Norfolk Vanguard Offshore Wind Farm

Applicant's Comments on Responses to the Examining Authority's Rule 17 Requests for Further Information

Document Reference: ExA; Rule17 Comments; 10.D9.5

Date: 6 June 2019

| DRAWING TITLE APPROACH DRIVER AWARENESS WORKS ON B1145 CAWSTON | | CLIENT ORSTED | |

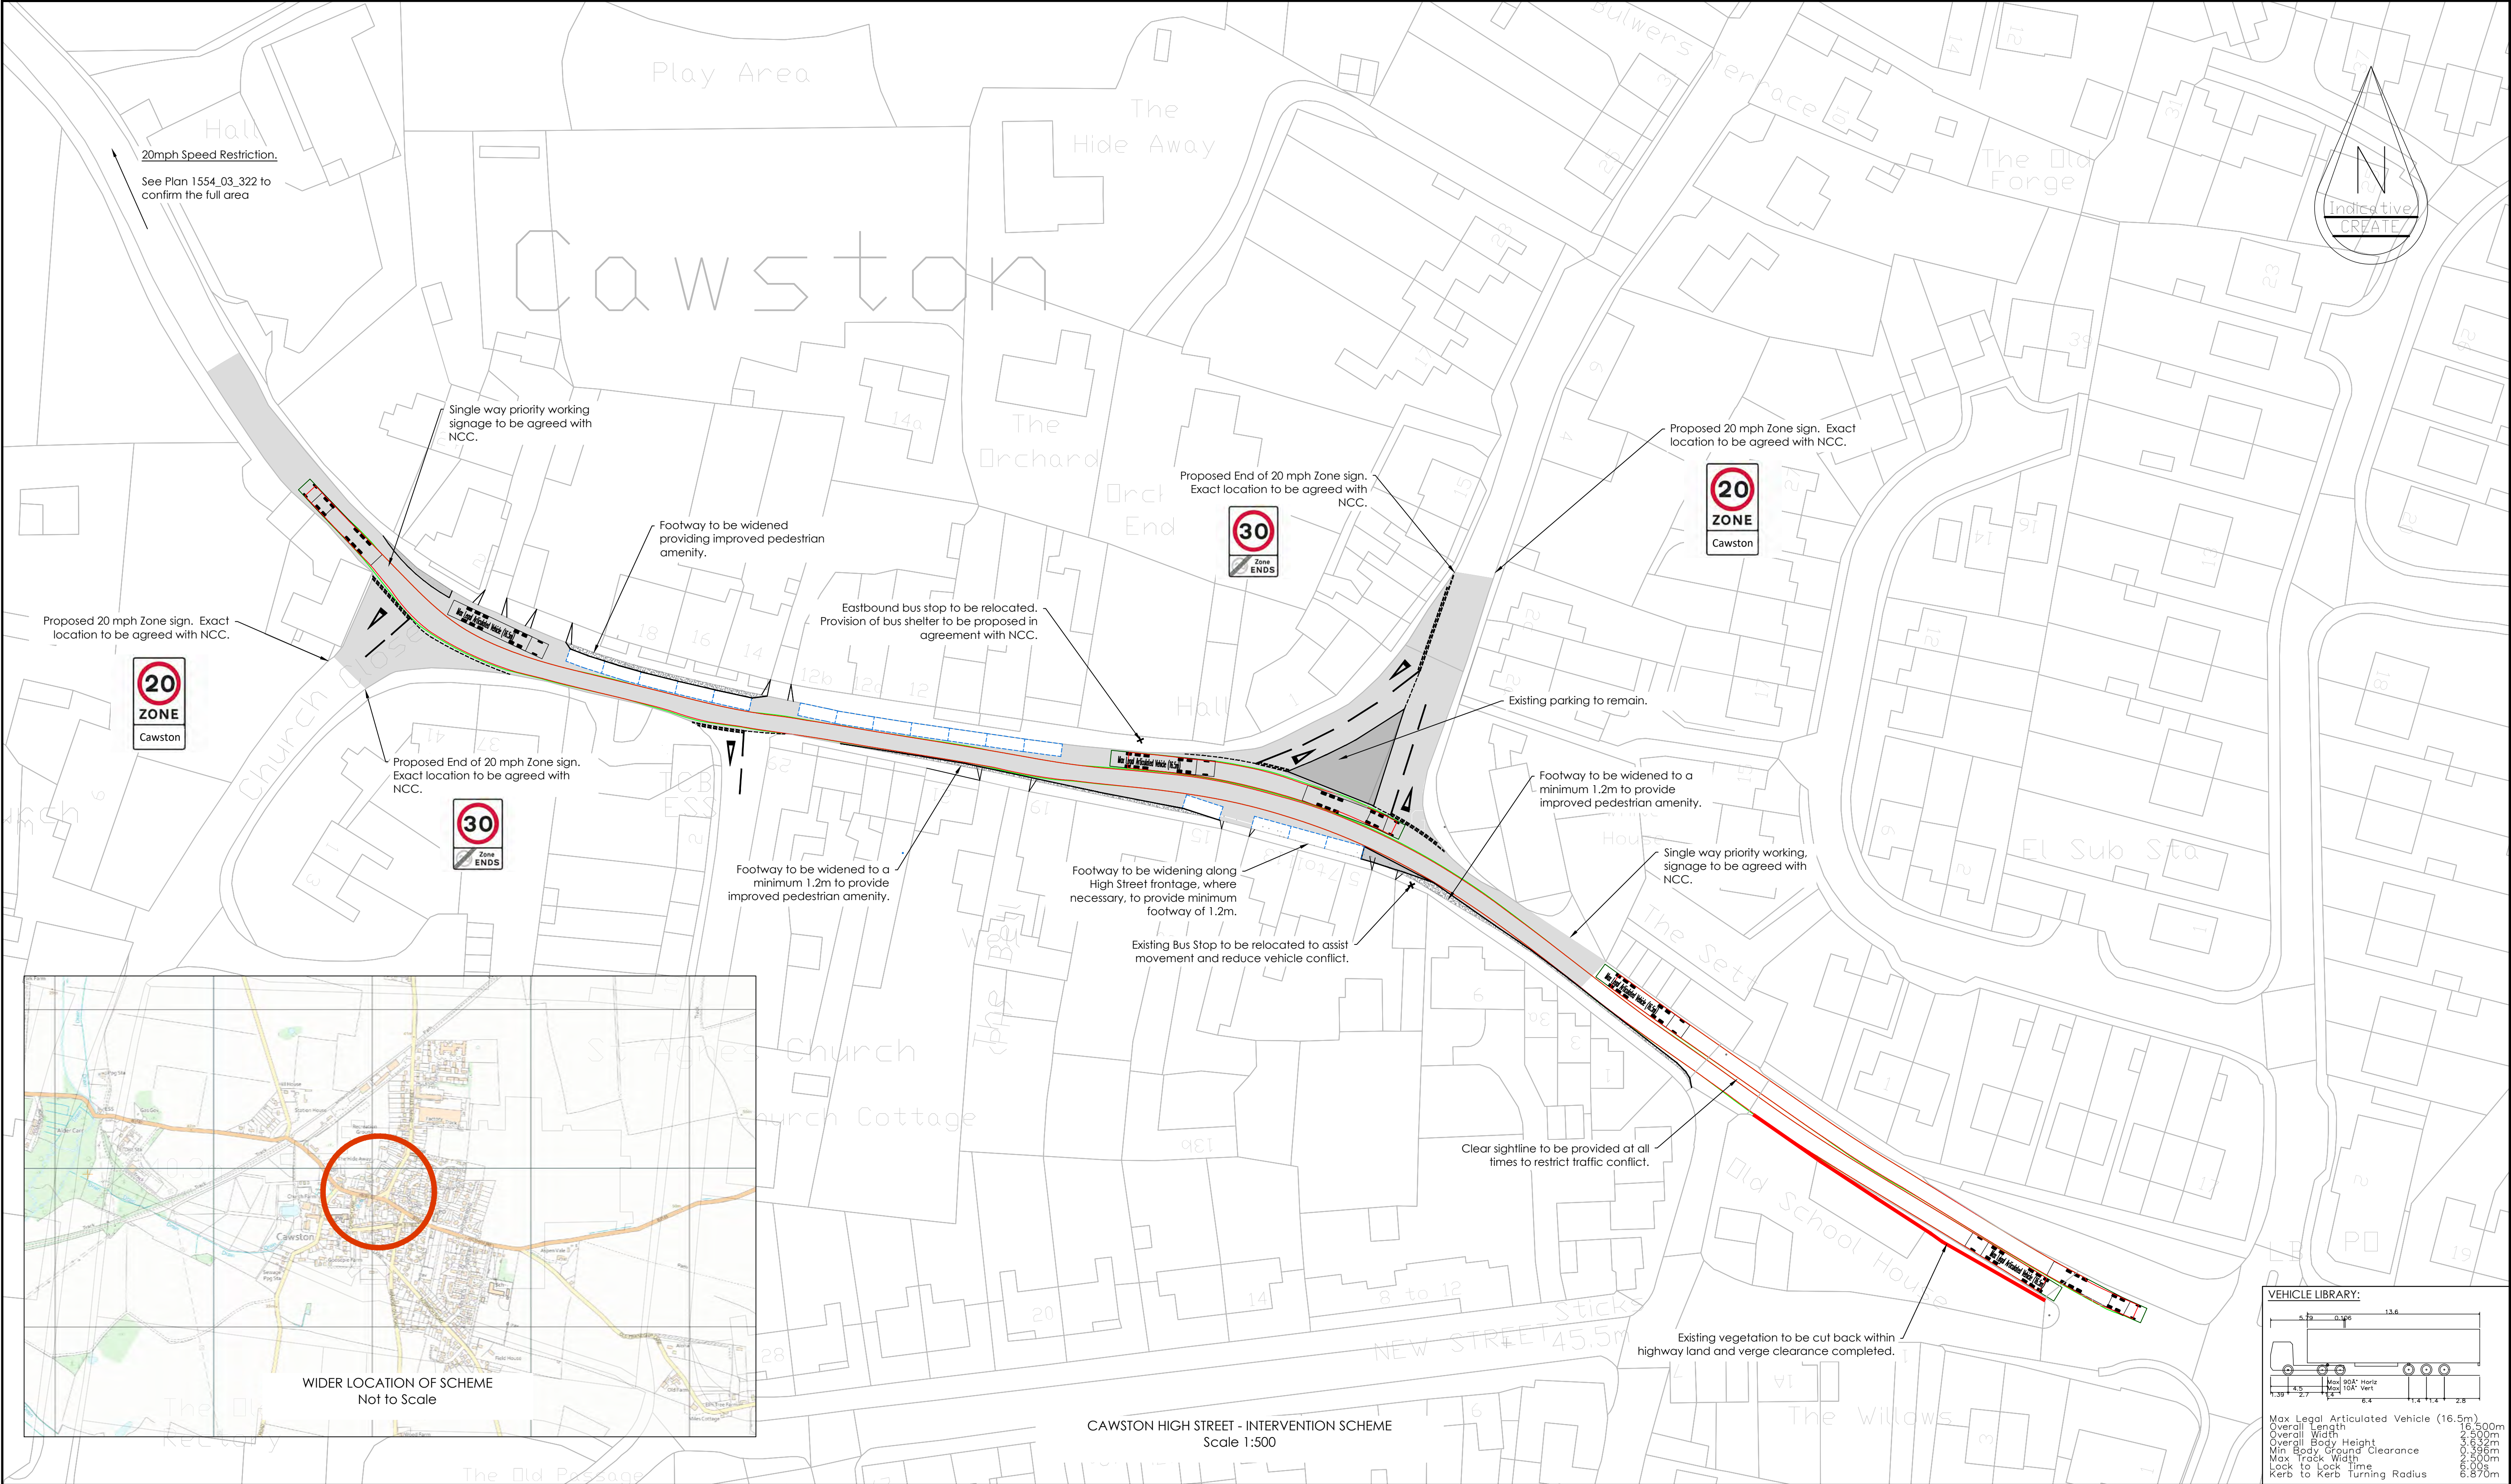
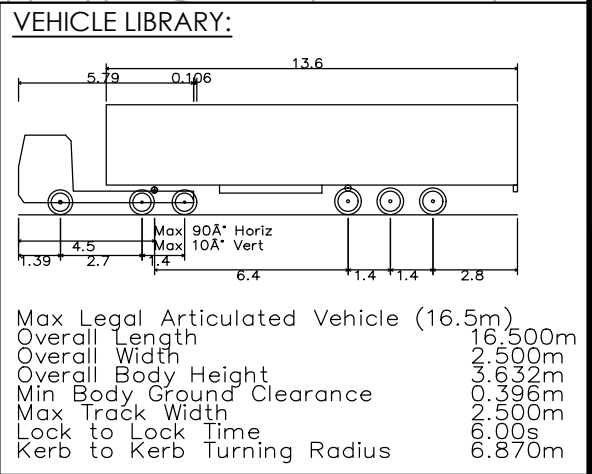
5.5	Norfolk County Council	<p>The H3 Highway Intervention Scheme dated March 2019 is still under consideration and it provides an illustration of some of the mitigation measures which could be utilised. This scheme retains some demarcated on-street parking which would result in HGVs having to wait in turn based upon 'single way priority working signage'. Having regard to the traffic movement figures above, namely one HGV every 2 minutes, how is it envisaged that such a scheme would work and be effective?</p> <p>In particular, how long would one HGV take to navigate the route through Cawston village. How long would the wait times be for HGVs travelling in the opposite direction?</p>	<p>The applicant has just advised us that they intend to reduce their HGV numbers by committing to a 1 week peak of 112 daily HGV movements (in both the single project and cumulative scenario), which will reduce down to 95 daily HGVs for a further 22 weeks, and then 44 daily HGVs for a further 13 weeks. We understand this will be confirmed within our joint position statement to be issued to the ExA later today.</p> <p>We further understand the applicant intends to submit calculations to the ExA in relation to both of the above questions, based upon their new revised figures. At this stage we are waiting to see the revised calculations before wishing to comment further.</p> <p>In the meantime, our position remains – we believe there is a reasonable expectation that a mitigation scheme can be produced to overcome the technical highway issues. However, until we receive a valid stage 1 Road Safety Audit, currently there is no</p>	<p>The Applicant has committed to a further reduction in the HGV cap for Norfolk Vanguard traffic through Cawston of a 1 week peak of 112 daily HGV movements (in both the single project and cumulative scenario), which will reduce down to 95 daily HGVs for a further 22 weeks, and then 44 daily HGVs for a further 13 weeks. The further reduction down to 112 is in response to concerns raised by the local community and is an effort to reduce daily HGV movements to as low as practicable within the existing construction programme by re-scheduling non-essential works. This commitment is captured within an update to the Outline Traffic Management Plan (document 8.8 version 3) submitted at Deadline 8.</p> <p>With the implementation of the HIS potentially significant pedestrian amenity impacts associated with the increase in daily HGV movements can be reduced to minor adverse significance.</p> <p>The Applicant would also wish to highlight that Norfolk County Council has requested that the Applicant does not make any alterations to the Highway Intervention Scheme as proposed by</p>

PINS Question Number	Question is addressed to:	Question:	Applicant's Response:
			<p>agreed mitigation scheme to overcome the identified issues for Cawston.</p> <p>Hornsea Project Three, as the Council is continuing to engage with Hornsea Project Three over an updated Road Safety Audit, and is keen that the scheme remains consistent for both projects.</p> <p>Norfolk County Council's position as set out in the joint position statement submitted at Deadline 8 (ExA; ISH6; 10.D8.2) states "NCC believes a suitable access strategy can be delivered that mitigates the traffic impacts through Cawston. The current proposal needs several amendments to address issues raised during the road safety audit, but that these can be addressed post-consent."</p> <p>The Applicant will continue to work with Norfolk County Council and Hornsea Project Three, during detailed design, to ensure that the amendments requested are addressed and that a suitable scheme is delivered accompanied with a valid Road Safety Audit.</p>
